Appendix N Arborist statement

Arborist Addendum; Darcy Road Multistorey Carpark, Westmead Hospital, WESTMEAD, NSW

In response to an email provided by Jane Fielding (14 January 2016), care of *Architectus*, and in relation to the modification to the proposed Westmead Darcy Road Multi Storey Car Park. This addendum addresses the proposed amendment to the architectural plans and impact on site trees. The modification has been referenced in the email to include;

DRAWING TITLE:
CARPARK SITE PLAN

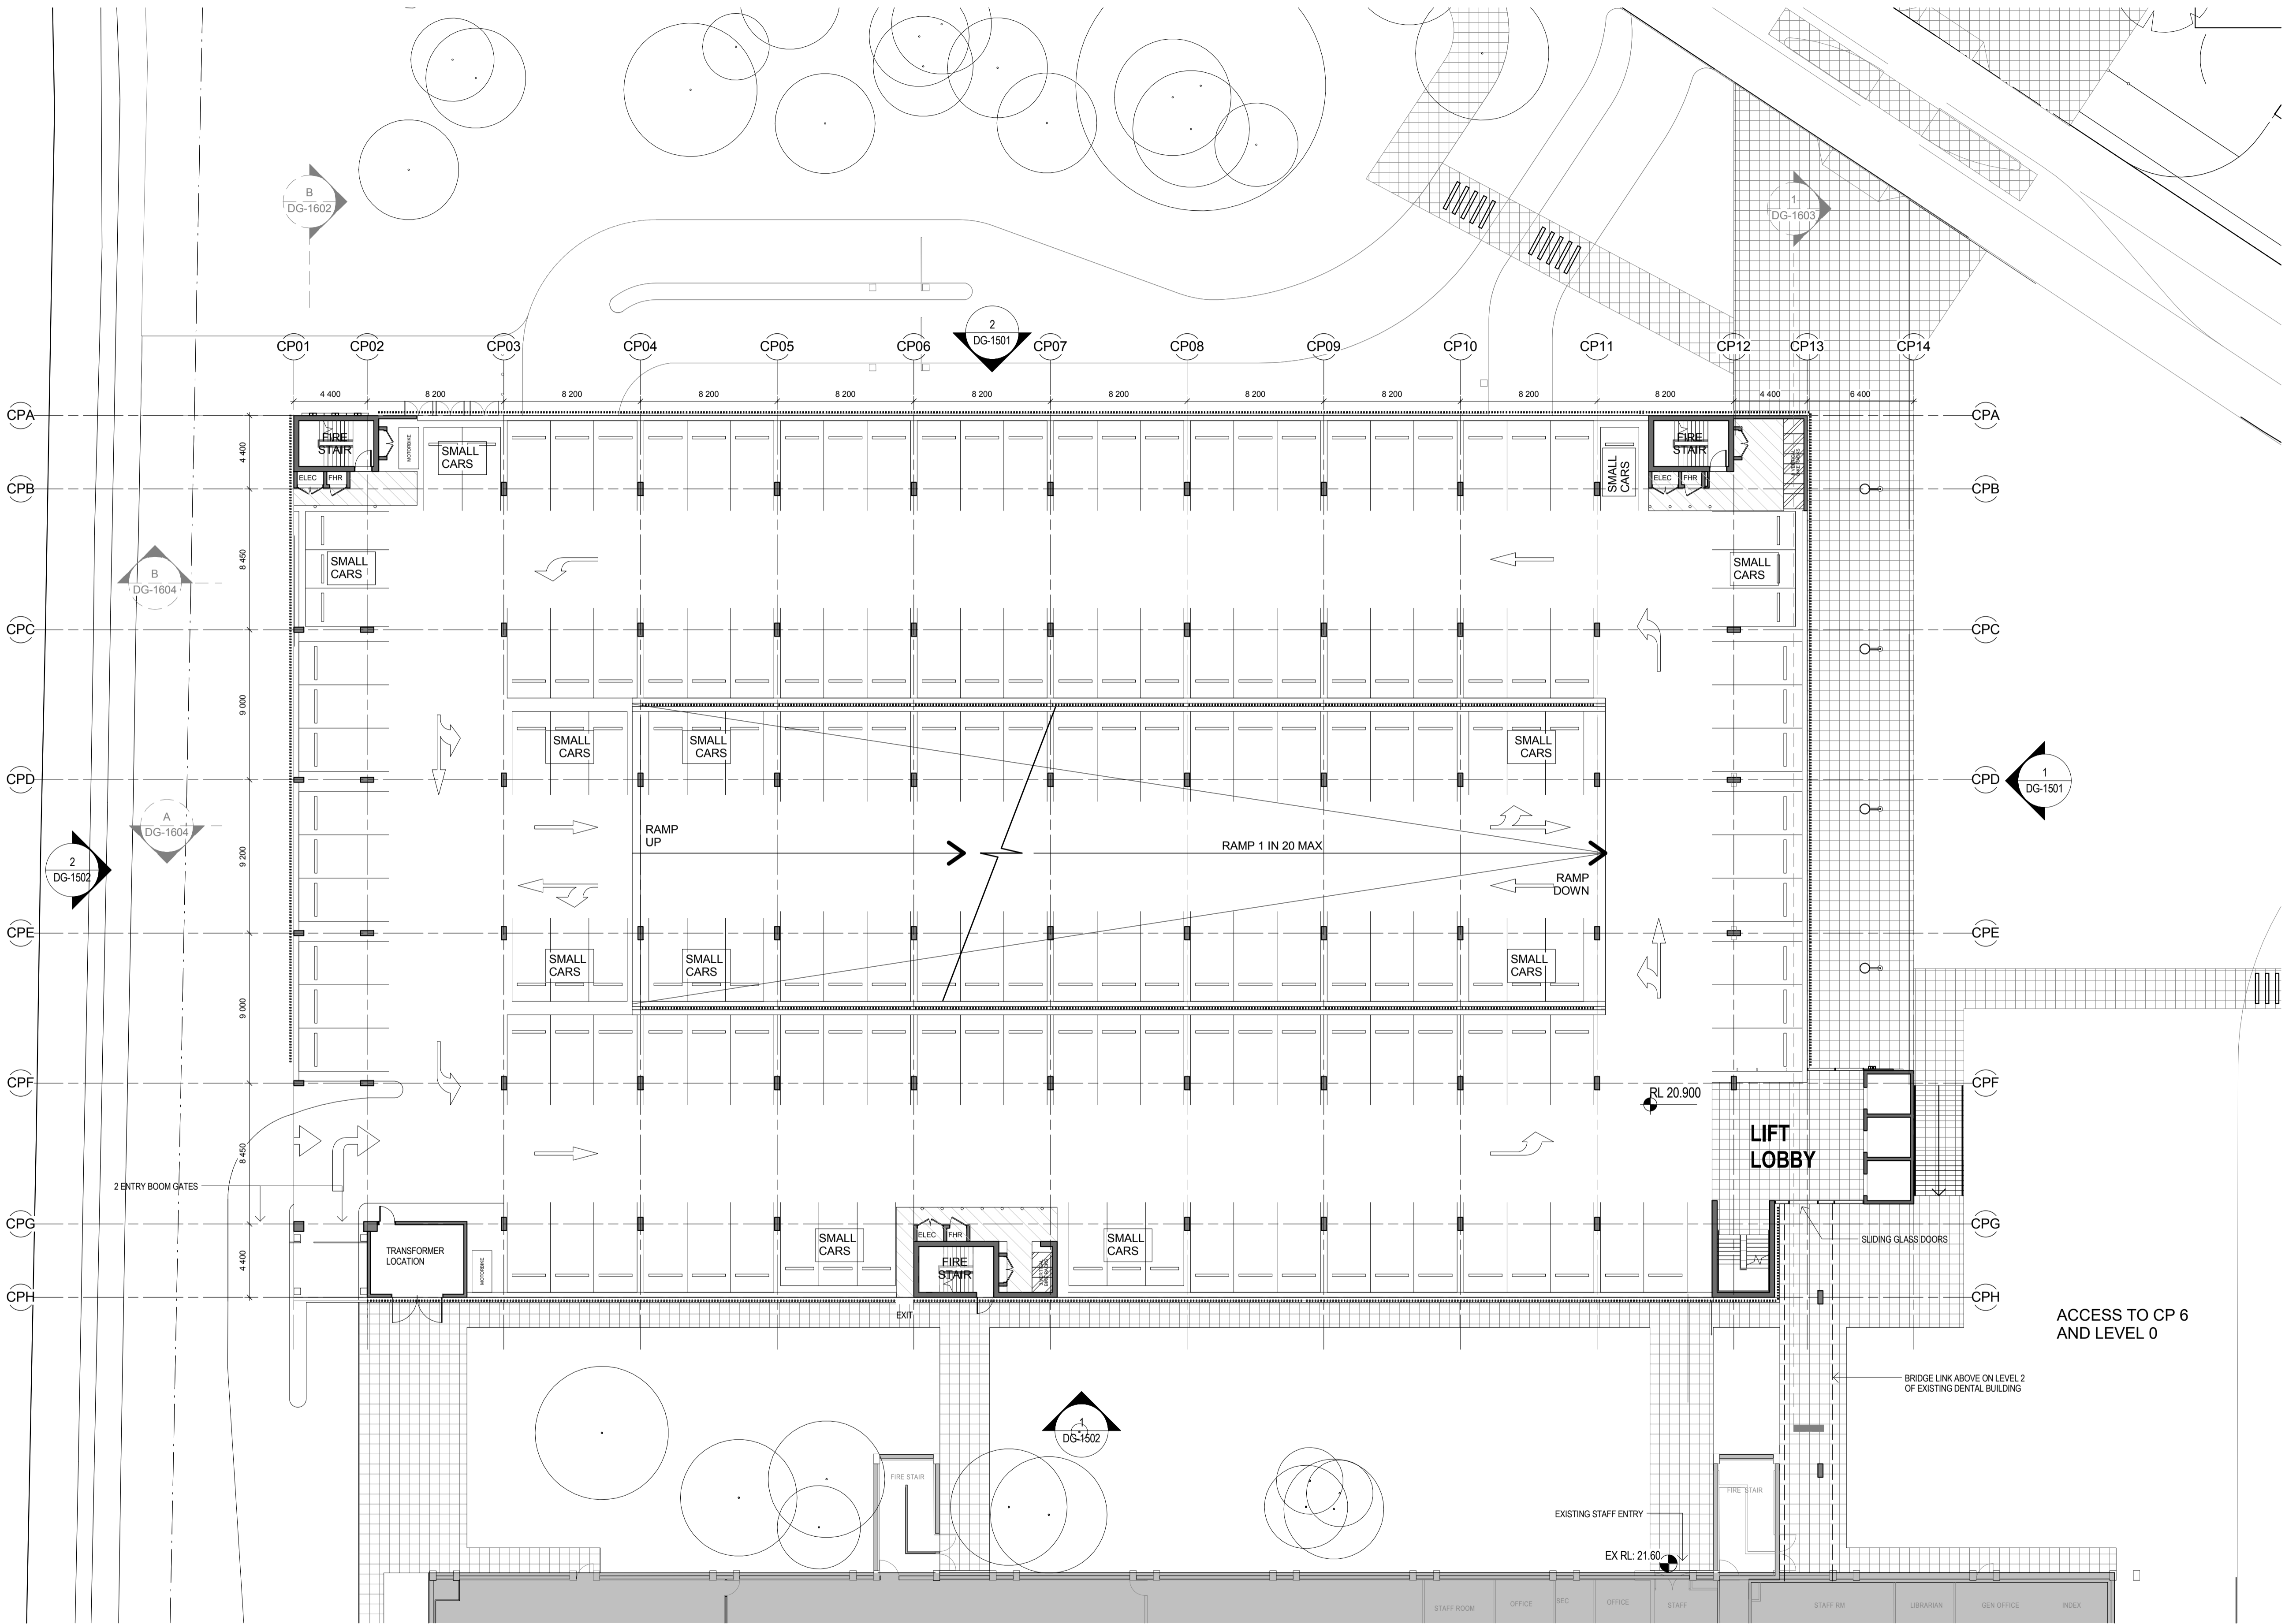
Accounting for this modified footprint, and the data provided in the Arboricultural Impact Assessment (referenced D2621, dated 12th October 2015), the following impacts on the site trees would occur;

- Building relocation: no further trees will require removal other than those that have been allowed for in this initial Arboricultural Impact Assessment.
- Entrance drive relocation: no further trees will require removal other than those that have been allowed for in this initial Arboricultural Impact Assessment.
- Substation: tree no. 433¹ (not included in supplied drawings) appears to conflict with the location, and would require removal. Trees no. 432² and 434³ are tree groups, and some trees within these groups may impact on the proposed location, pending the extent of excavation required relative to the tree vicinity. These are young trees with further substantial mature growth expected. The mature growth of some of these trees would be expected to compromise (concrete base) this structure, via root growth. The

extent of impact (that is, encroachment on the zones of protection⁴) on these trees cannot be determined because the individual locations have not been included in the drawings supplied.
